RE: UTS Central DA s96, Reflectivity Report

UTS have requested Surface Design to review the s96 DA documents in relation to our previously provided Reflectivity Report dated 28 April 2016 (drawings provided by fjmt and as attached to this letter). Refer to the enclosed description of the project and s96 details.

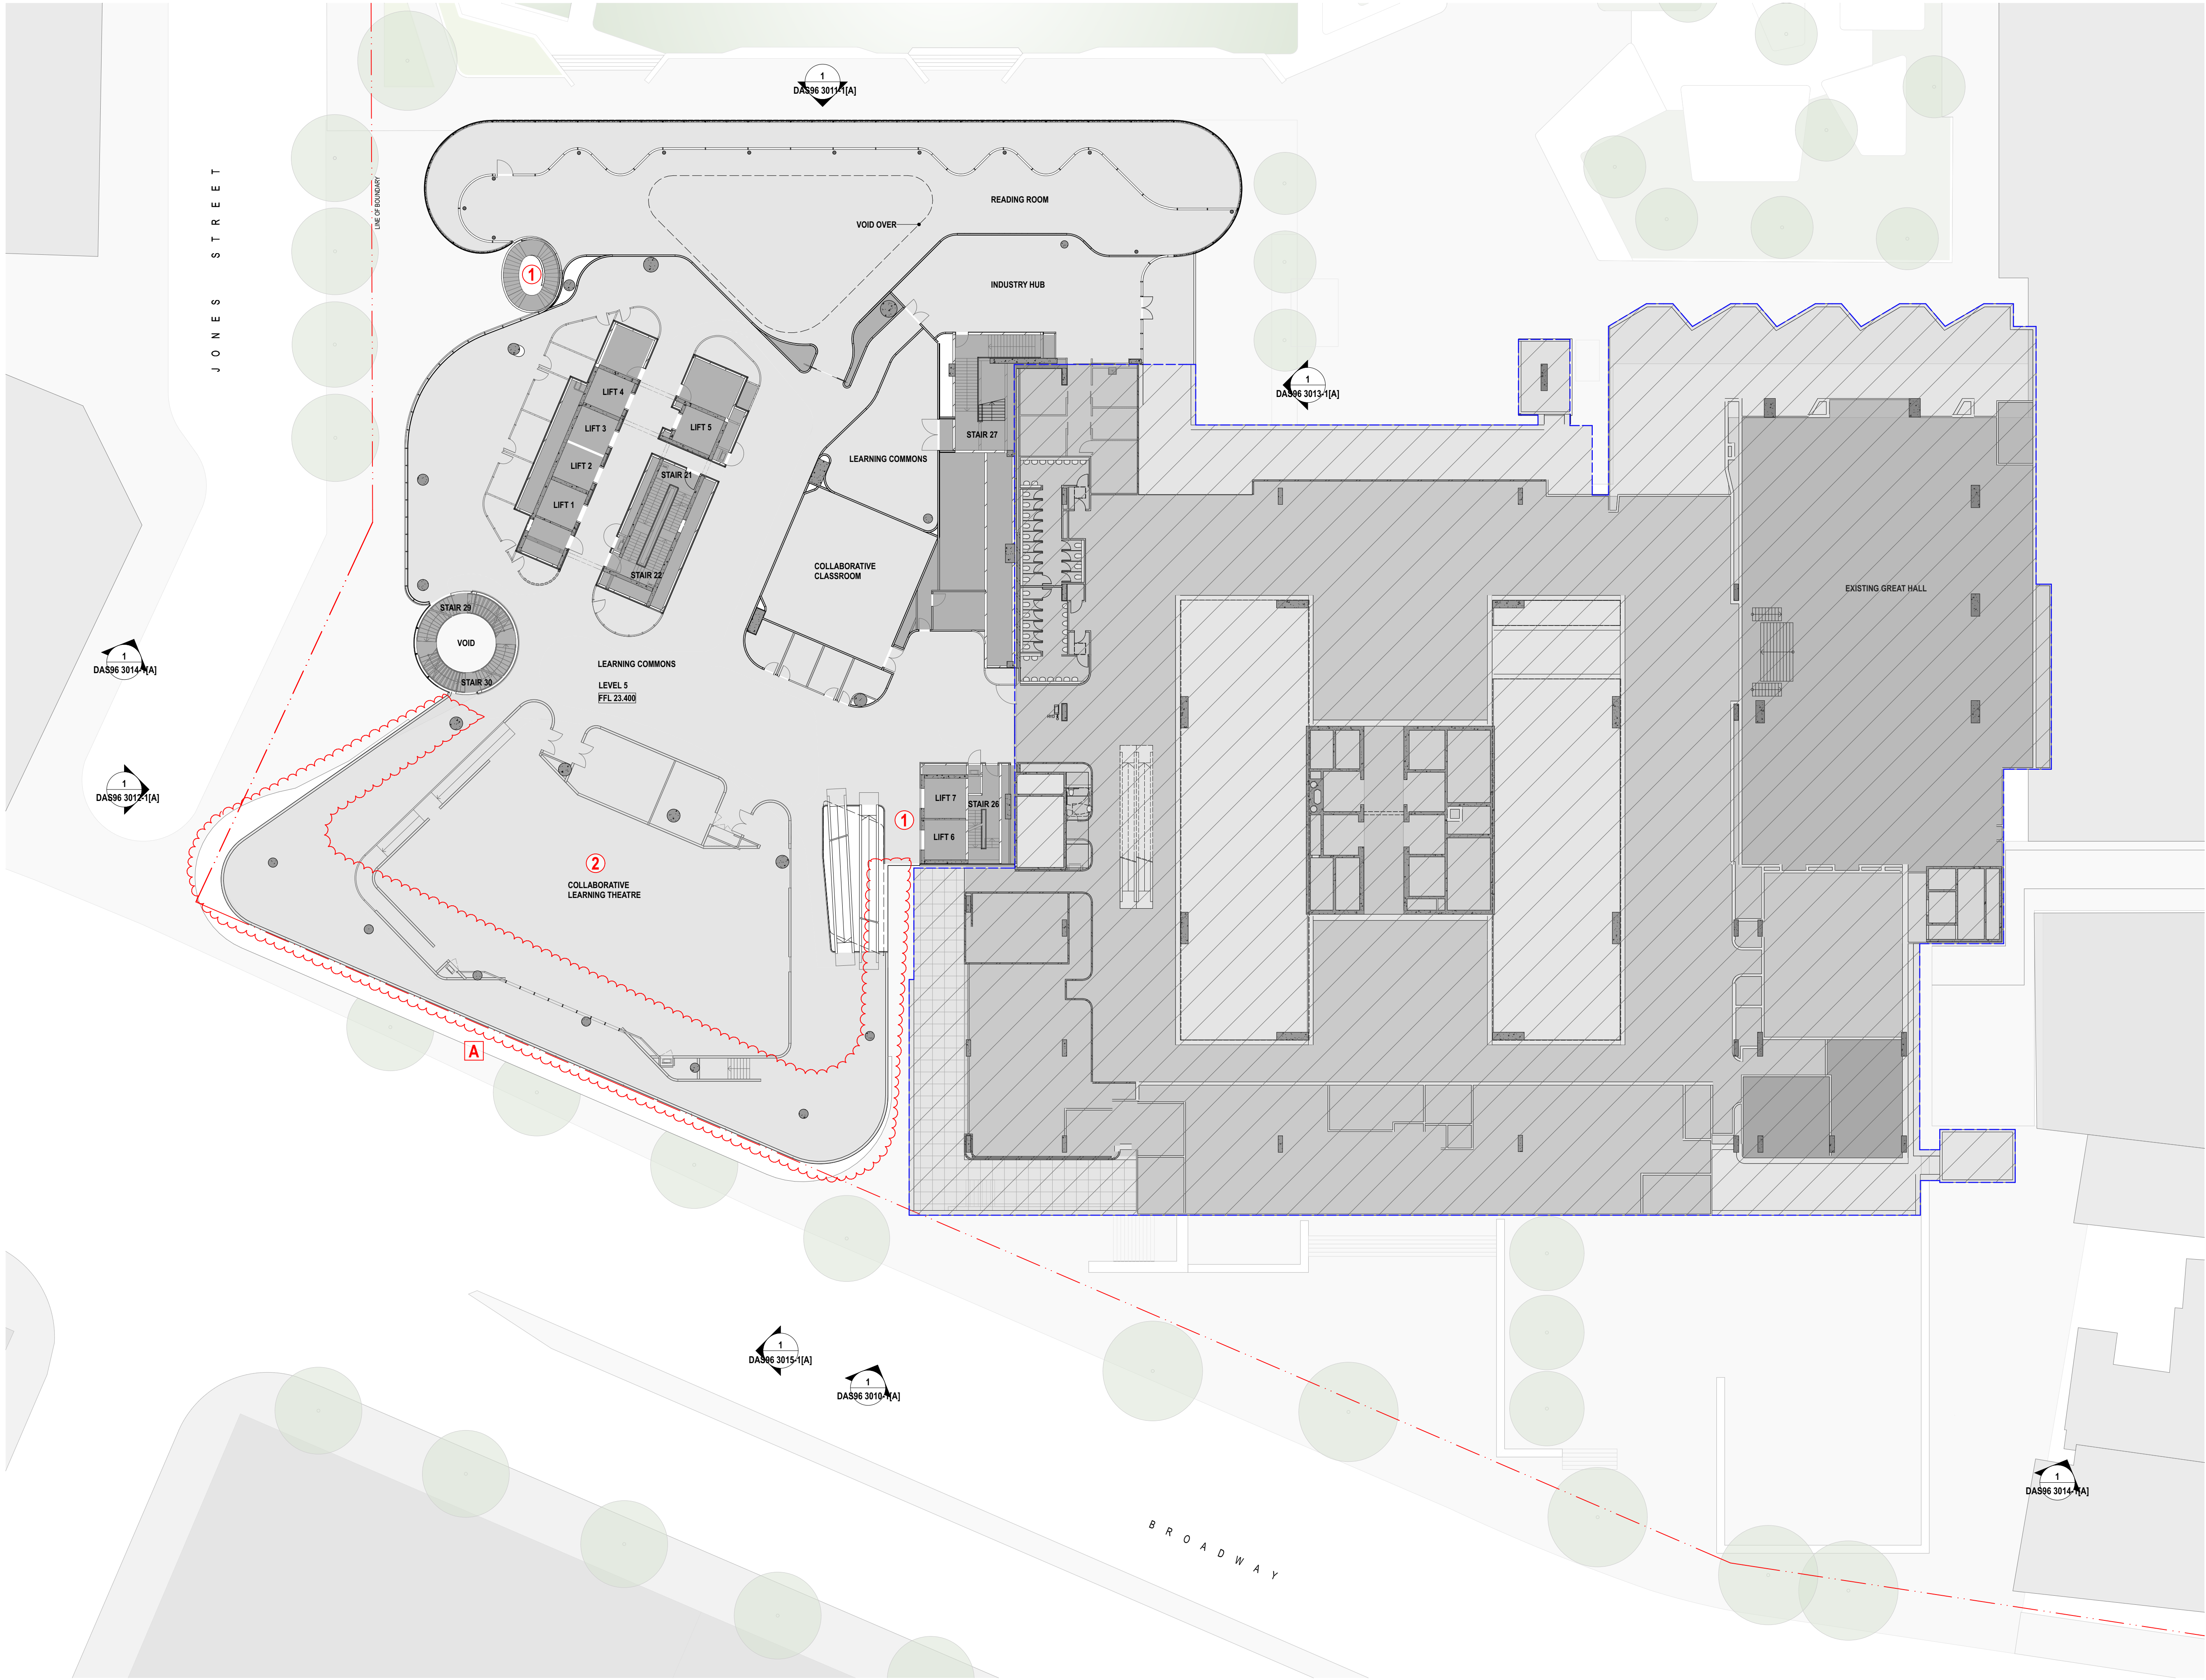
1. The re-alignment of the façade to the boundary is a minor change in relation to the façade reflectivity assessment. The Broadway façade up to the boundary is addressed in the existing Reflectivity Report dated 28 April 2016, with key viewpoints 3 and 8. The outcome of the existing report remains current and the Broadway façade is to have a maximum spectral reflectivity of 20%. The current design has accounted for this provision in the design

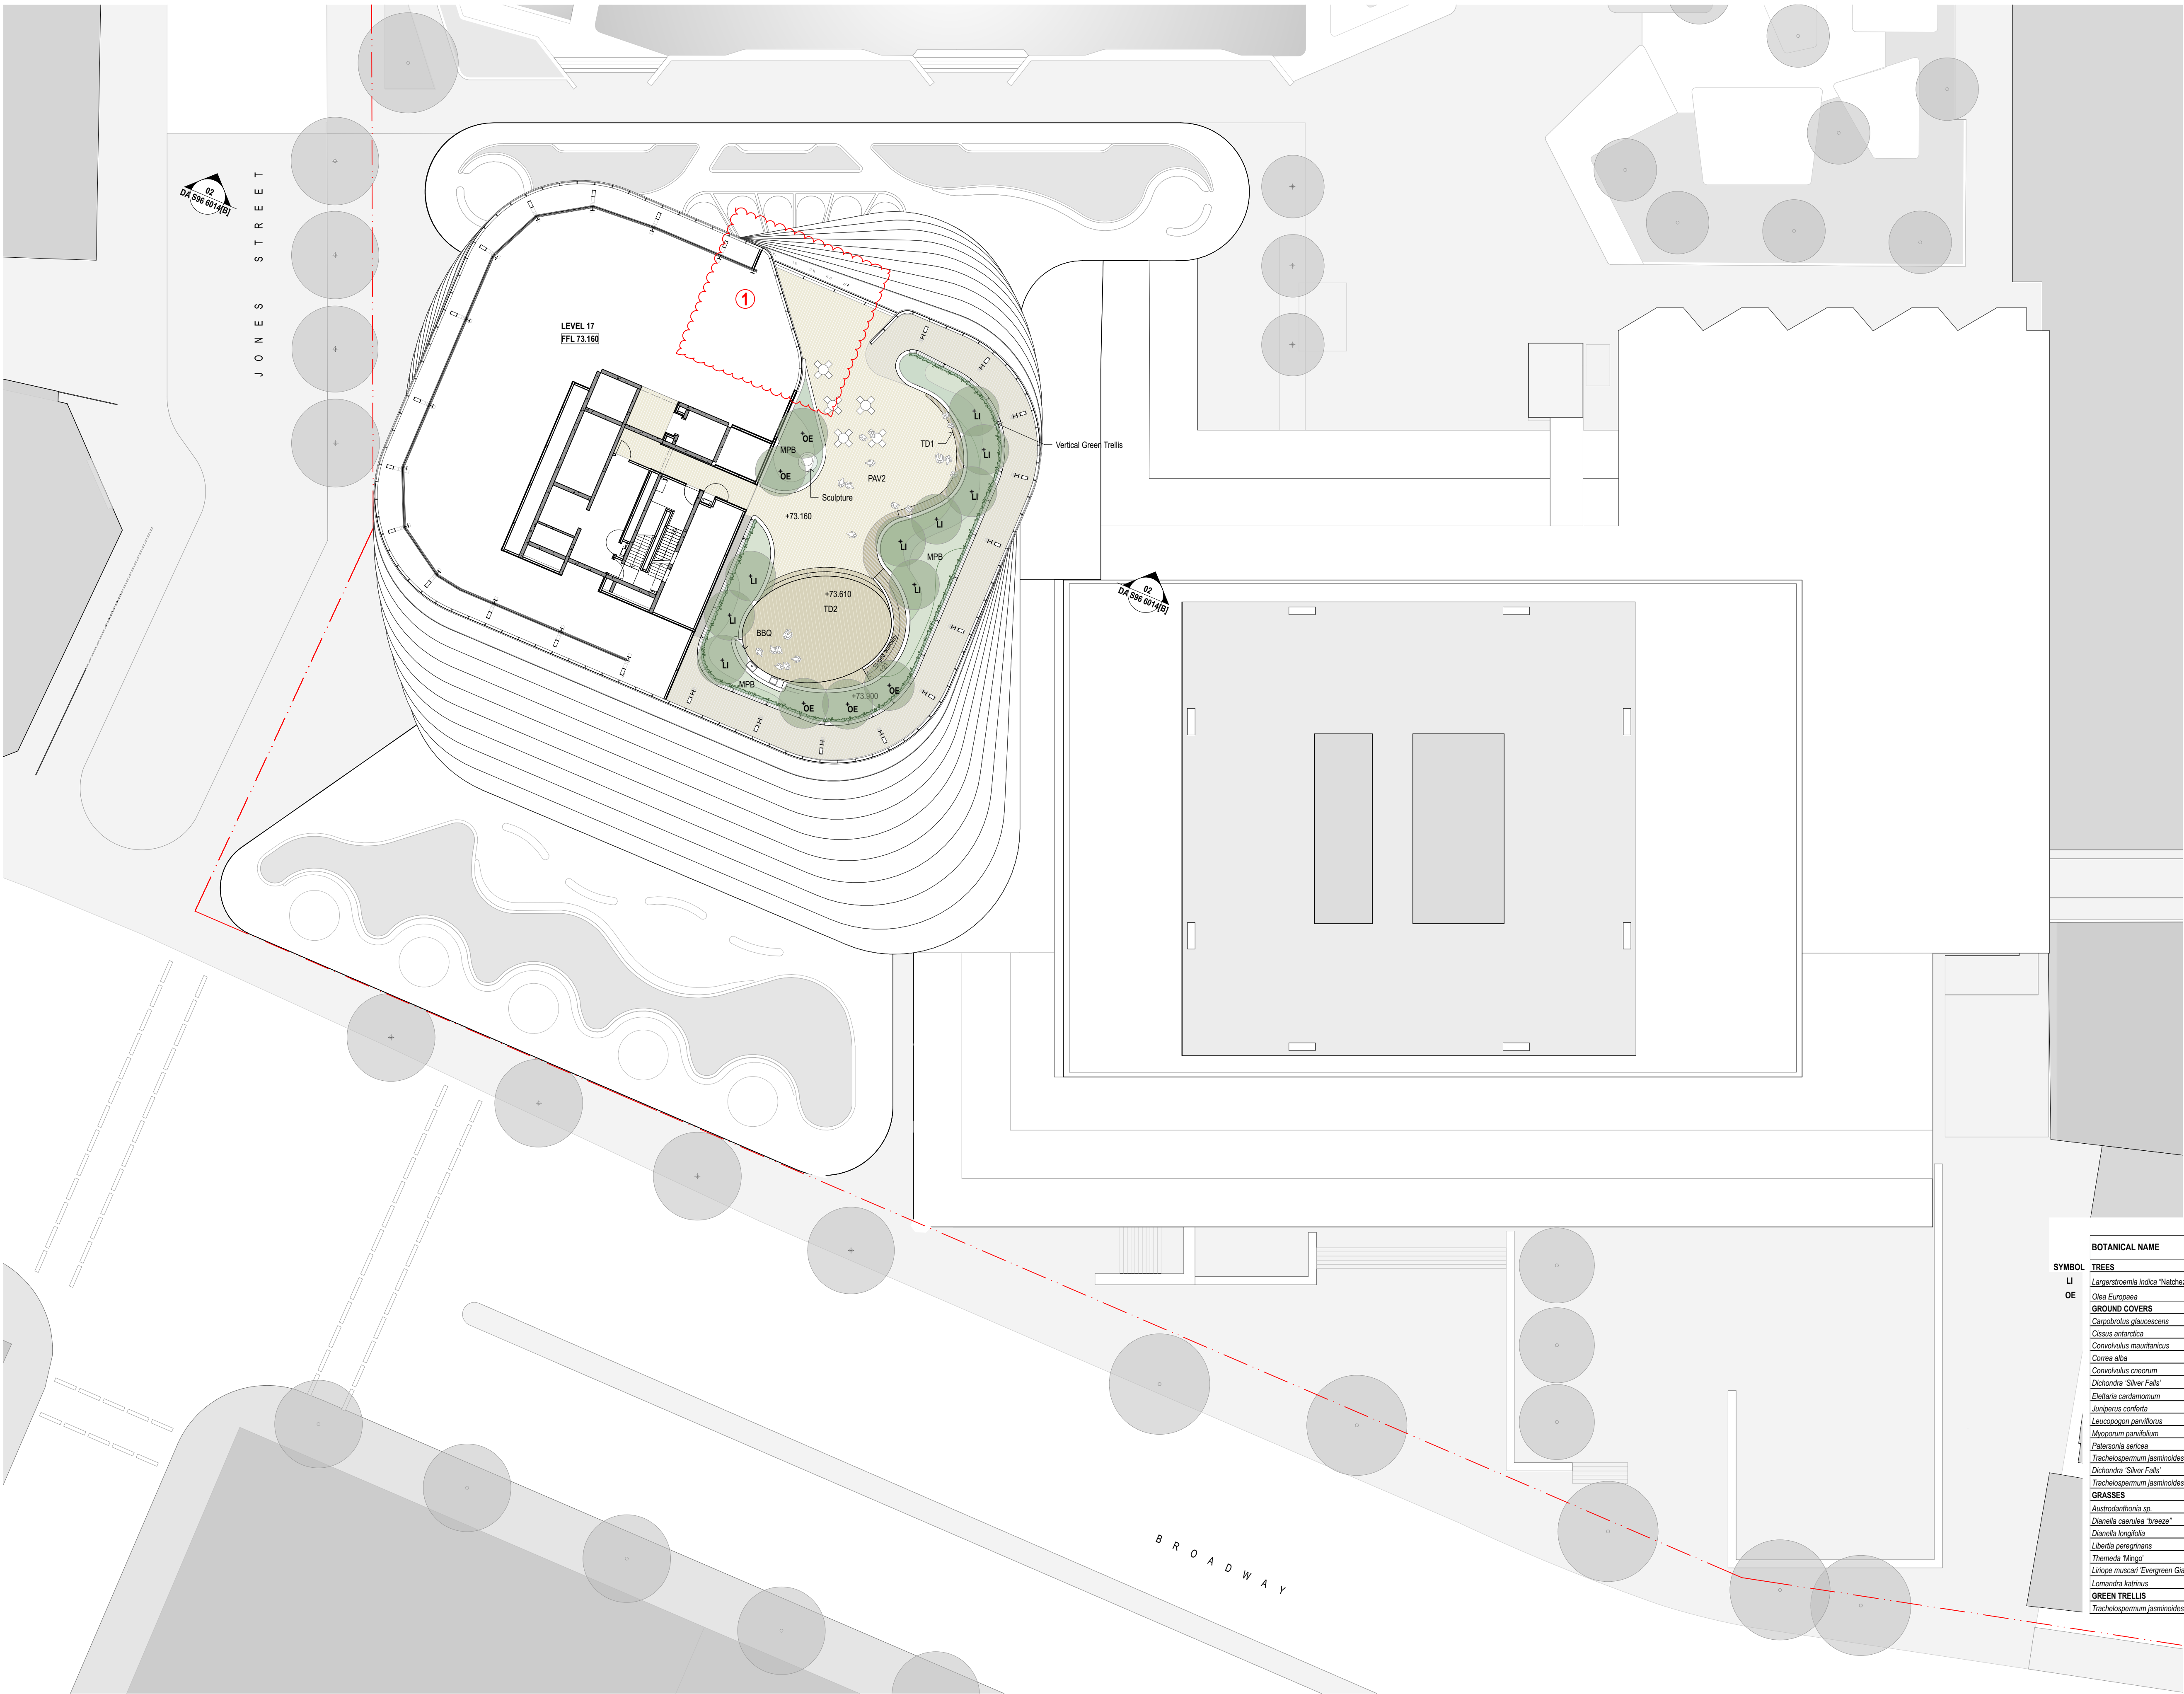
4. The development of landscaping has no impact on the reflectivity to pedestrians and motorists. Any materials used for sculptural element or furniture is have a maximum spectral reflectivity of 20% in accordance with the Reflectivity Report.
